DEPARTMENT OF PUBLIC WORKS

MEMORANDUM

SUBJECT: Meadow Springs, Starlite Heights, and Tamarack Ridge – Traffic Impact Analysis

Title:
 SITE PLAN
 OF
MEADOW SPRINGS

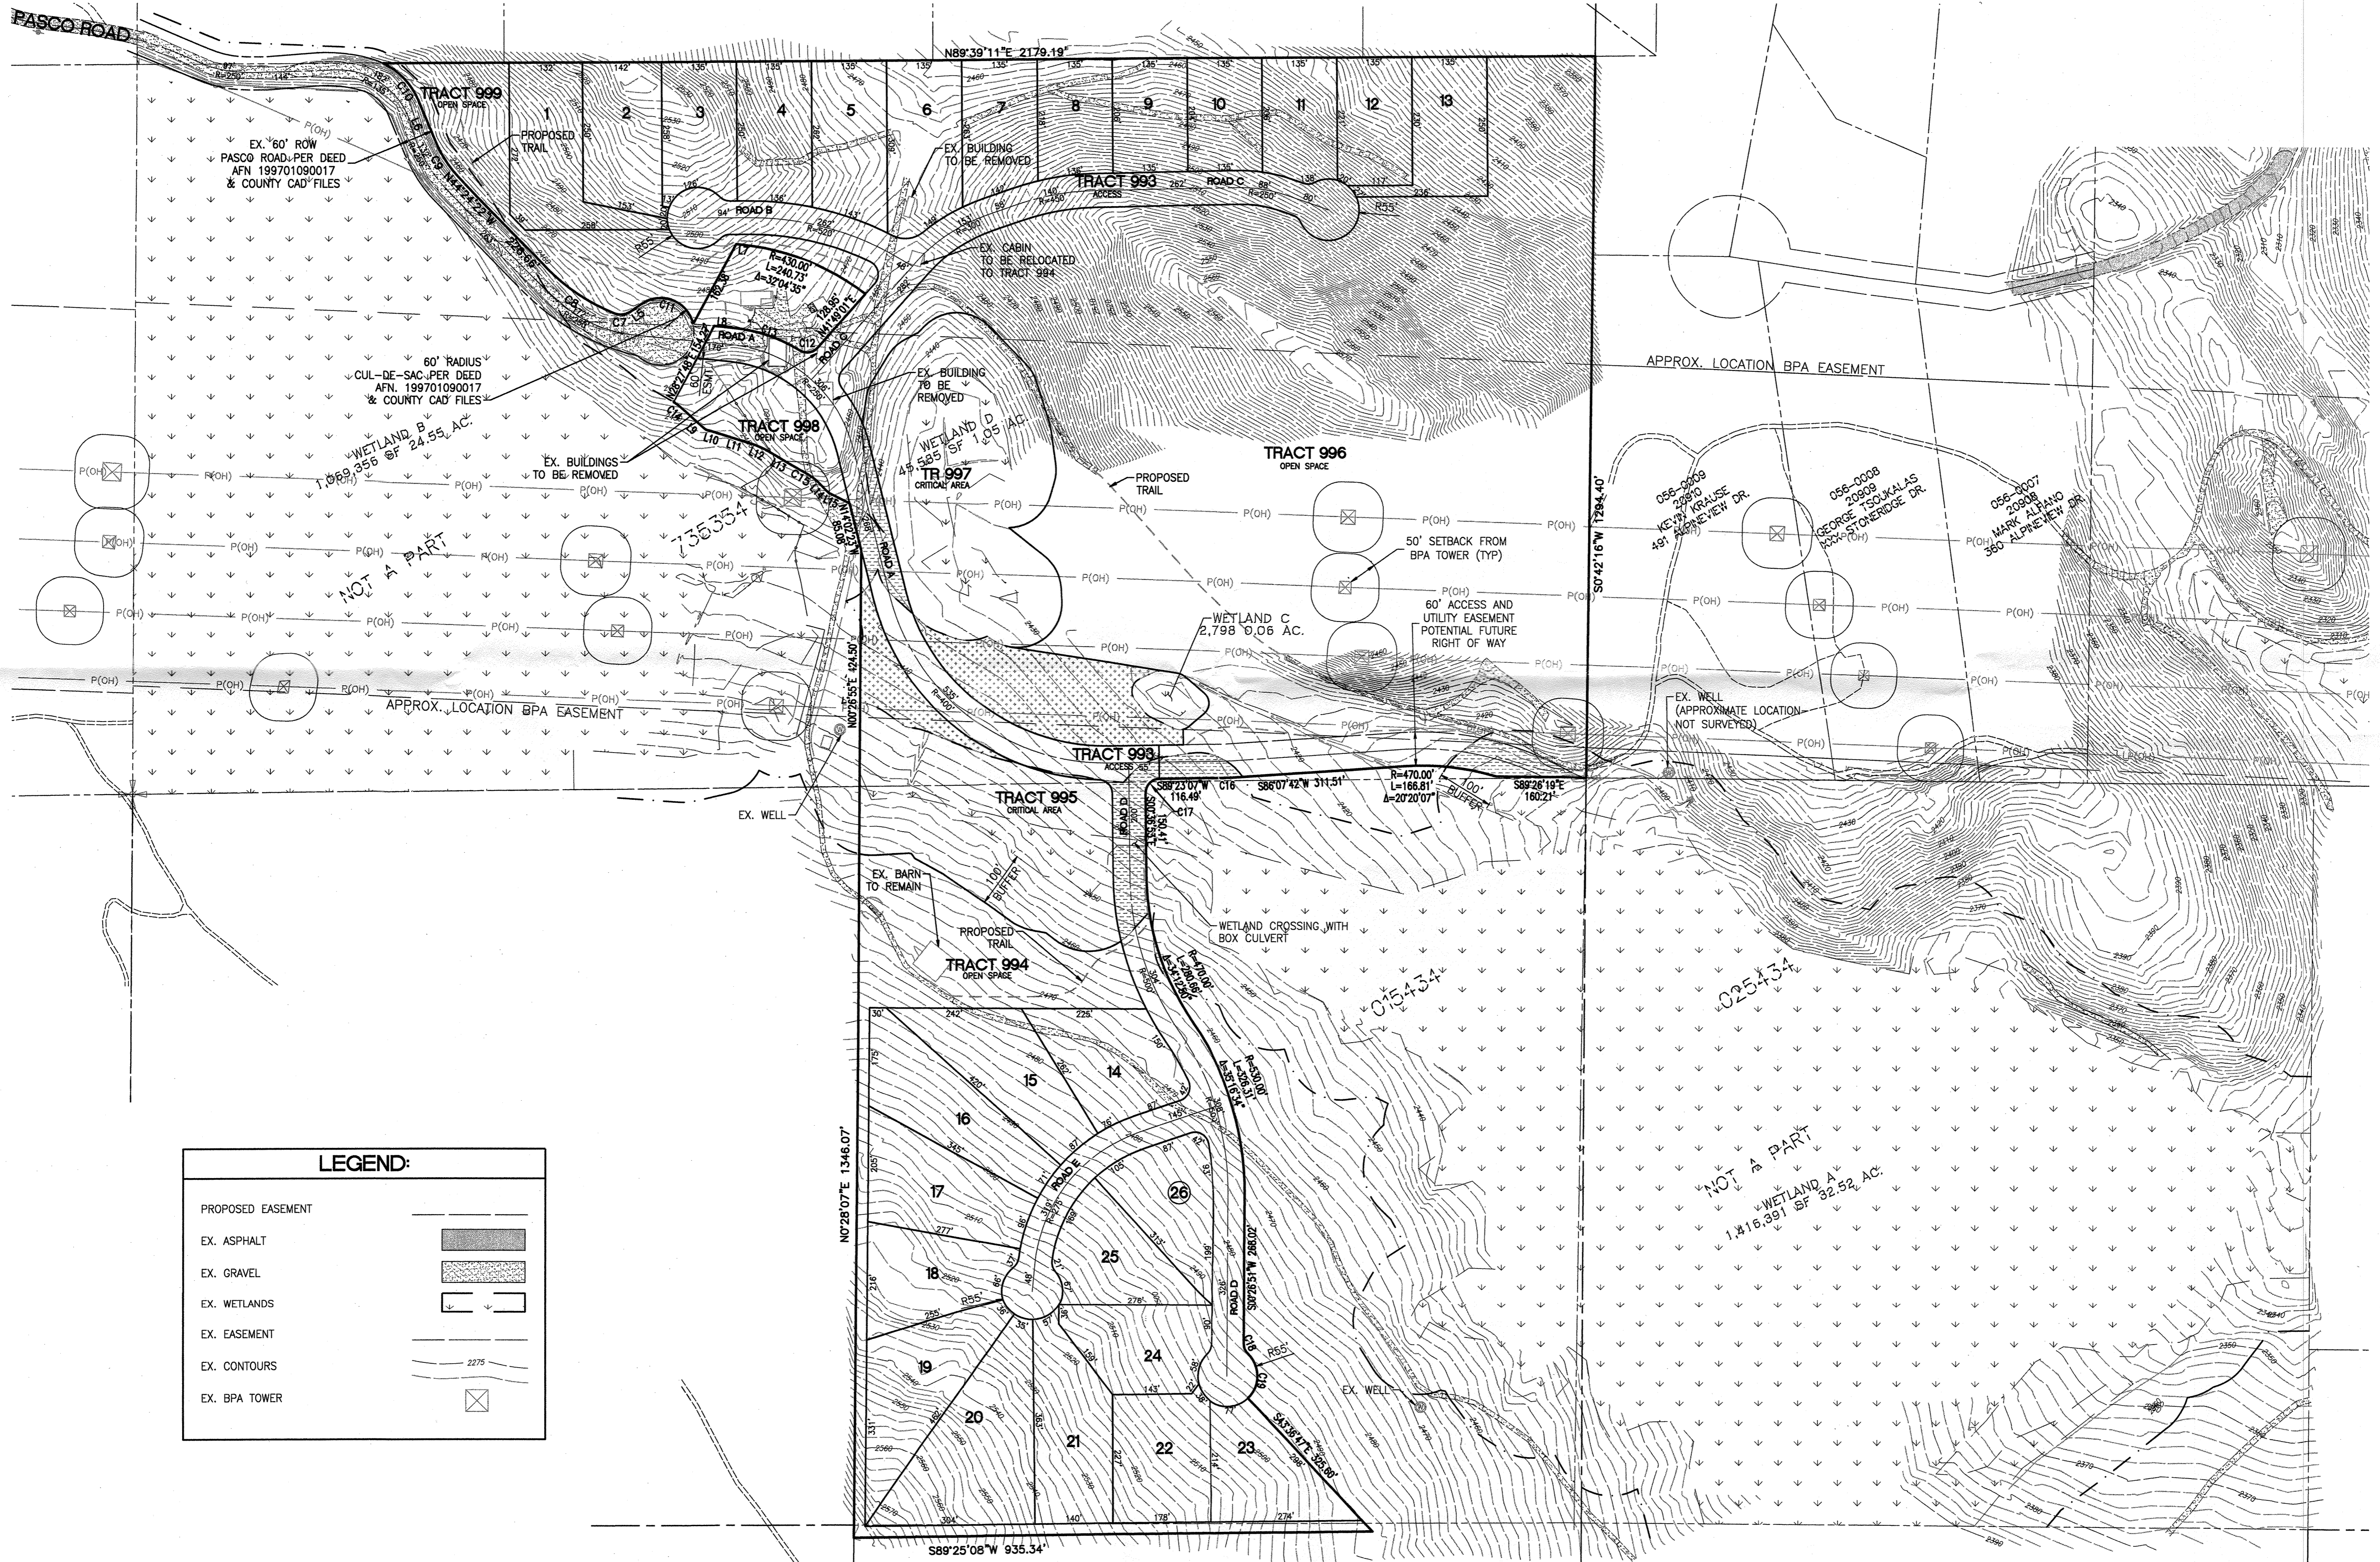
1. Right Turn Pocket/Taper: Traffic volumes generated by these residential developments warrant the addition of a right turn pocket or right turn taper from Westside Road eastbound into the development site access. The applicant shall design, receive approval from Public Works for the design, and construct this improvement. The configuration requirements are shown in Figure 910-12 of the WSDOT Design Manual (see attachment).

The addition of a right turn pocket or taper shall be incorporated into the development's access road and bridge design. A turnout for a school bus stop and mail boxes shall be considered and incorporated in the design of the right turn pocket or taper.

2. Road Connections: The second access from the development site to Pasco Road shall not be gated. Public access shall be permitted between Pasco Road and Westside Road through this development by dedicating the right of way to the county. This public access route between Pasco Road and Westside Road shall be built to public road standards for rural local access roads that have Average Daily Traffic (ADT) above 750.

This road connection from Westside Road to Pasco Road will provide better connectivity between county roads and improved access for Pasco Road residents. It is unlikely that the residents in the applicant's developments would drive a long circuitous route from the development site to Pasco Road to Fowler Creek Road to Westside Road on a regular basis when they have direct access to Westside Road - these residents would use the second access route primarily as an emergency entrance/exit or during a road closure. However, it would provide Pasco Road residents an alternative route in order to access Westside Road and would result in reducing traffic impacts on Fowler Creek Road and Fowler Creek Road's intersection with Westside Road. Improving the connectivity of roads is one of Public Work's goals for this vicinity and providing a gated second access is contrary toward achieving better connectivity for these roads.
